The Planning Inspectorate

Our Ref: TR050006

Planning Act 2008 (as amended) – Section 51

Application by Roxhill (Junction 15) Limited for an Order Granting Development Consent for the Northampton Gateway Rail Freight Interchange

INSET (B) Knock Lane / Blisworth Road

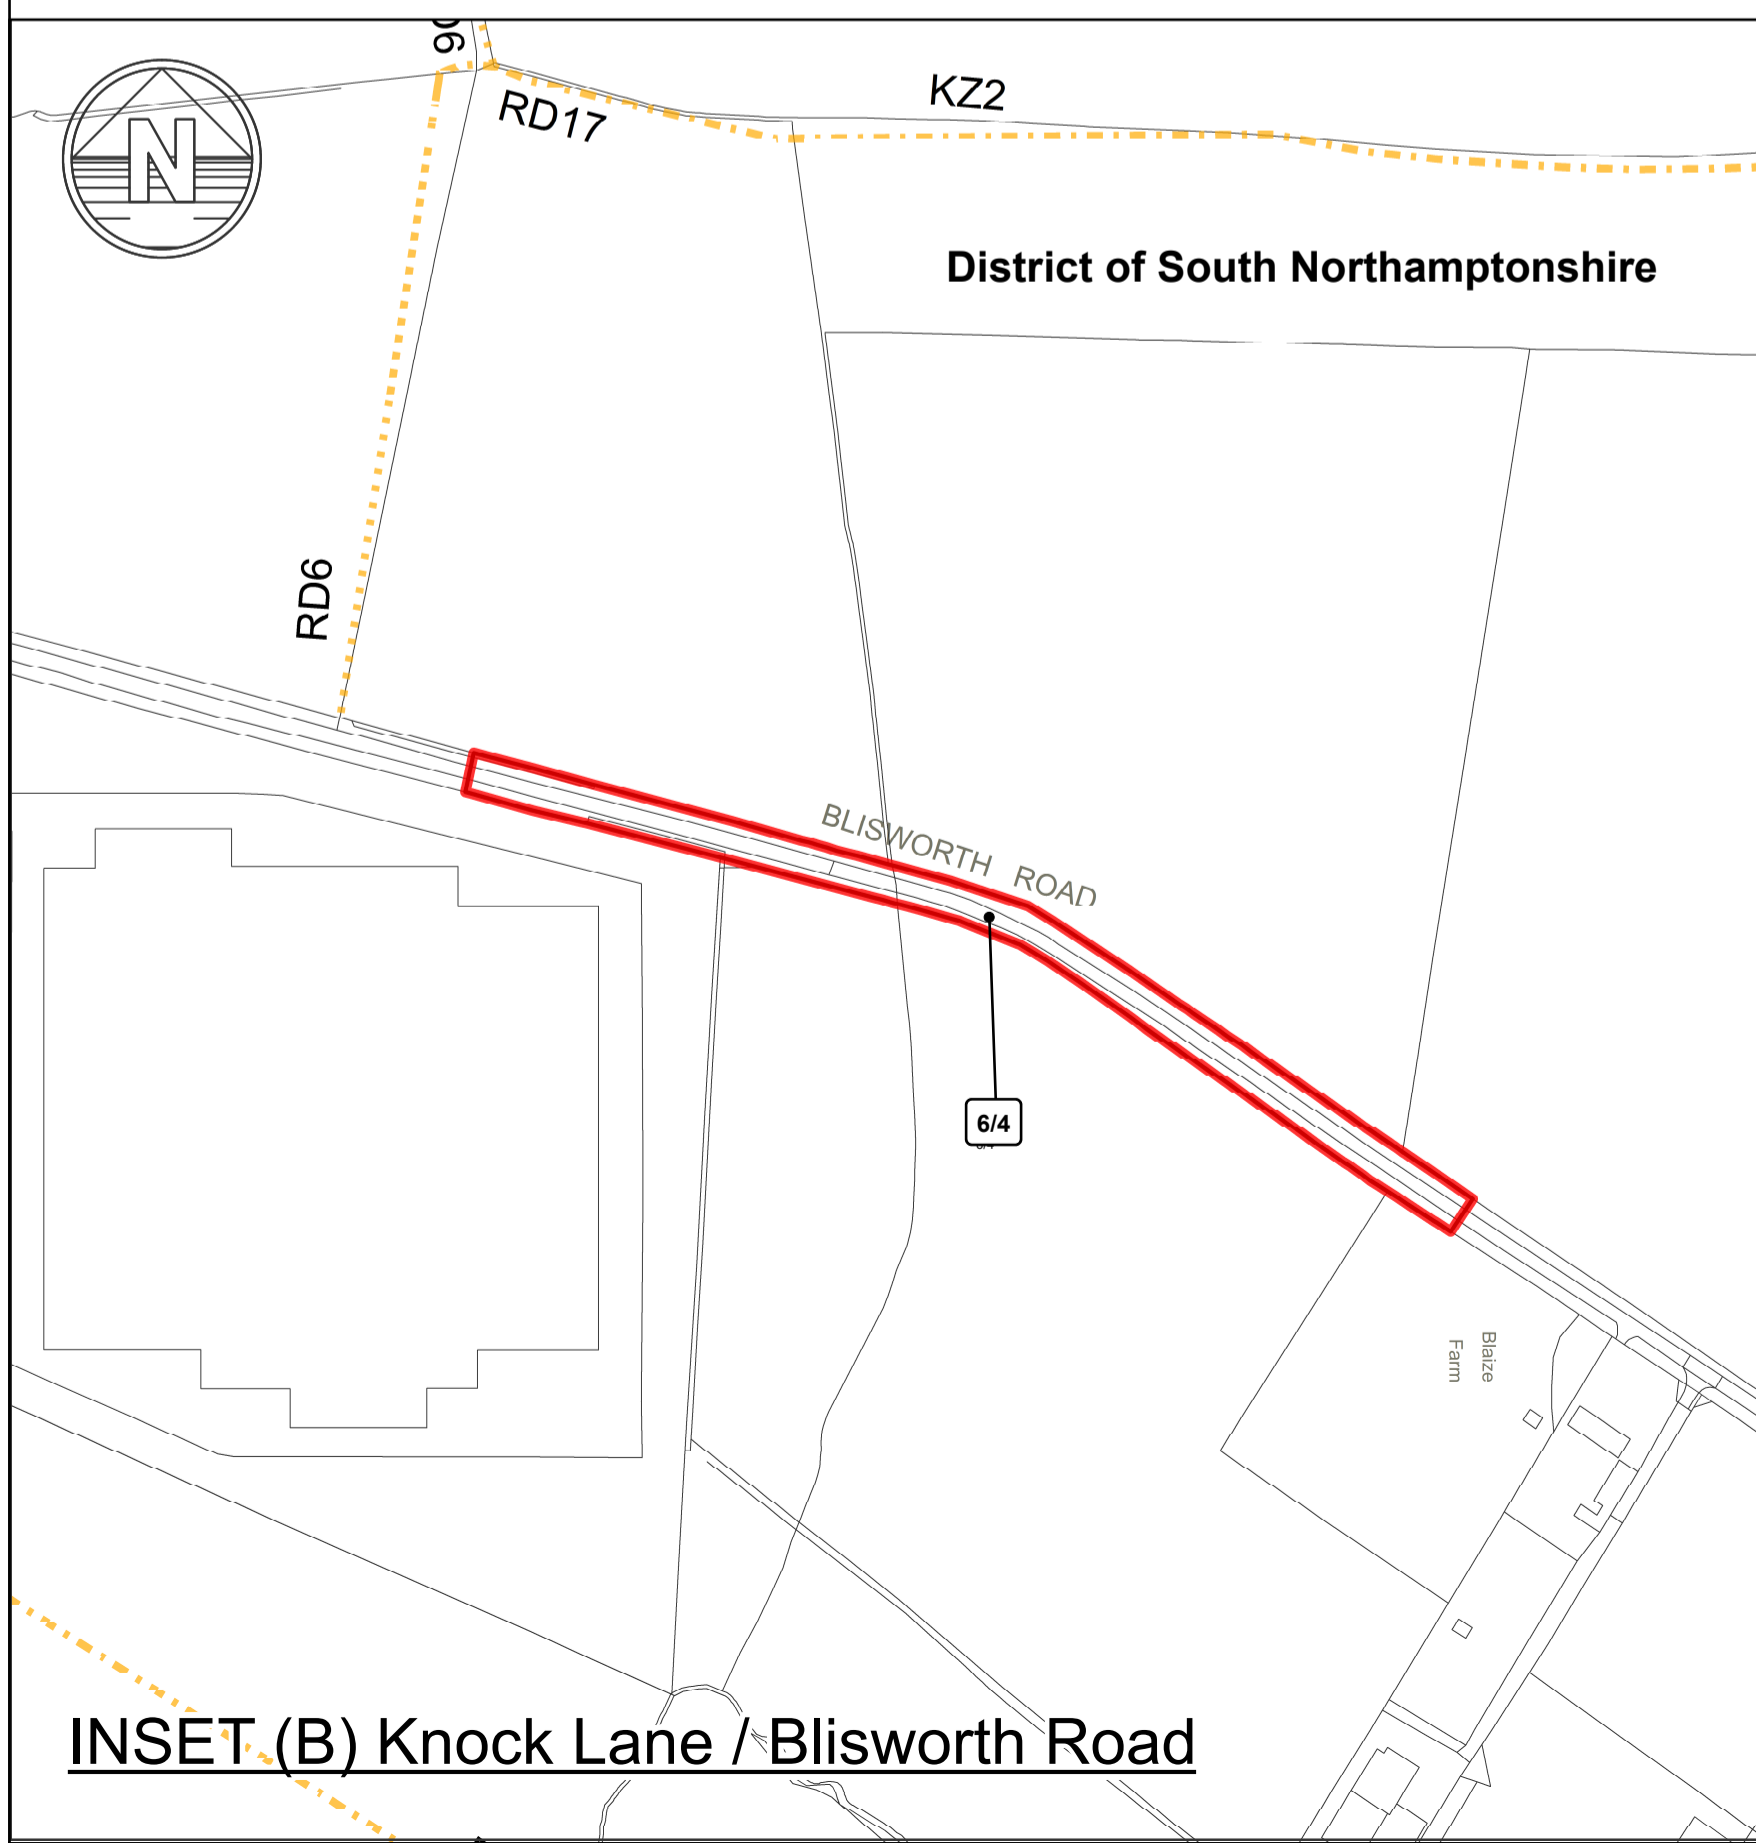
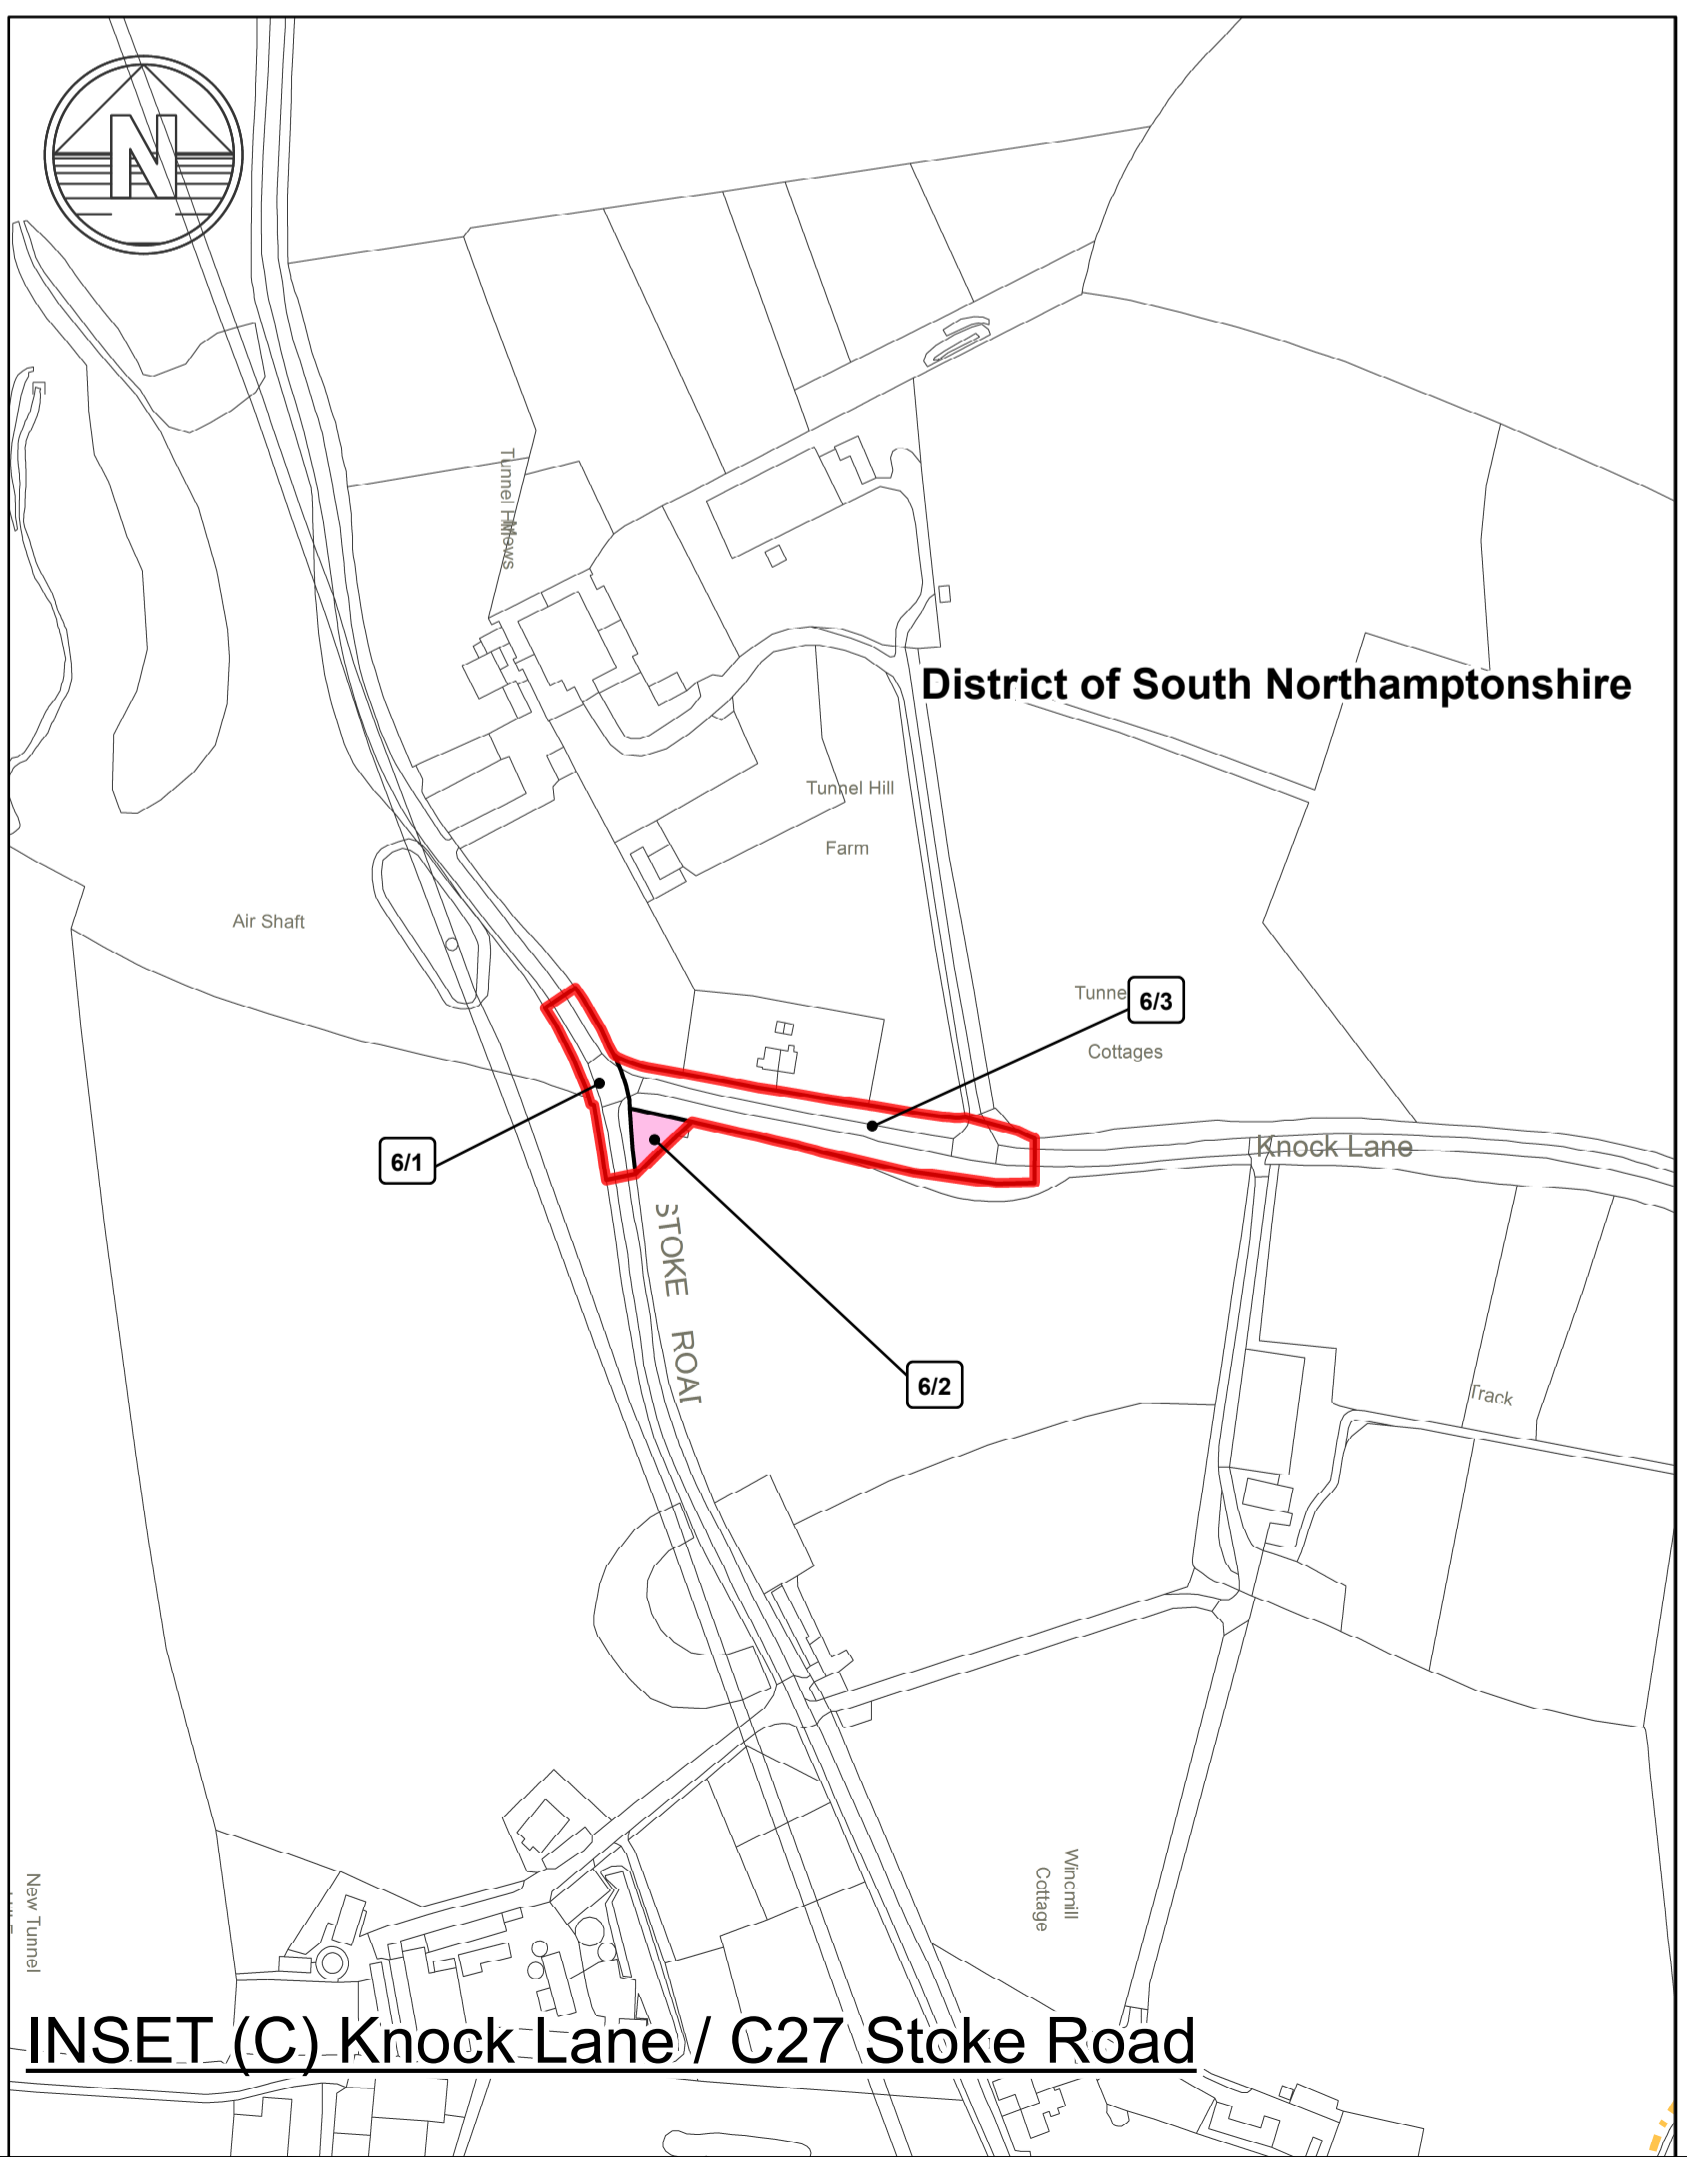
The following plots on the land plans cannot be seen clearly: 2/29, 6/8, 6/12, 6/15 & 6/16. On sheet 6 of the land plans the point at which plots 6/5, 6/6, 6/8 & 6/9 meet is unclear. The Applicant should consider providing updated plans.
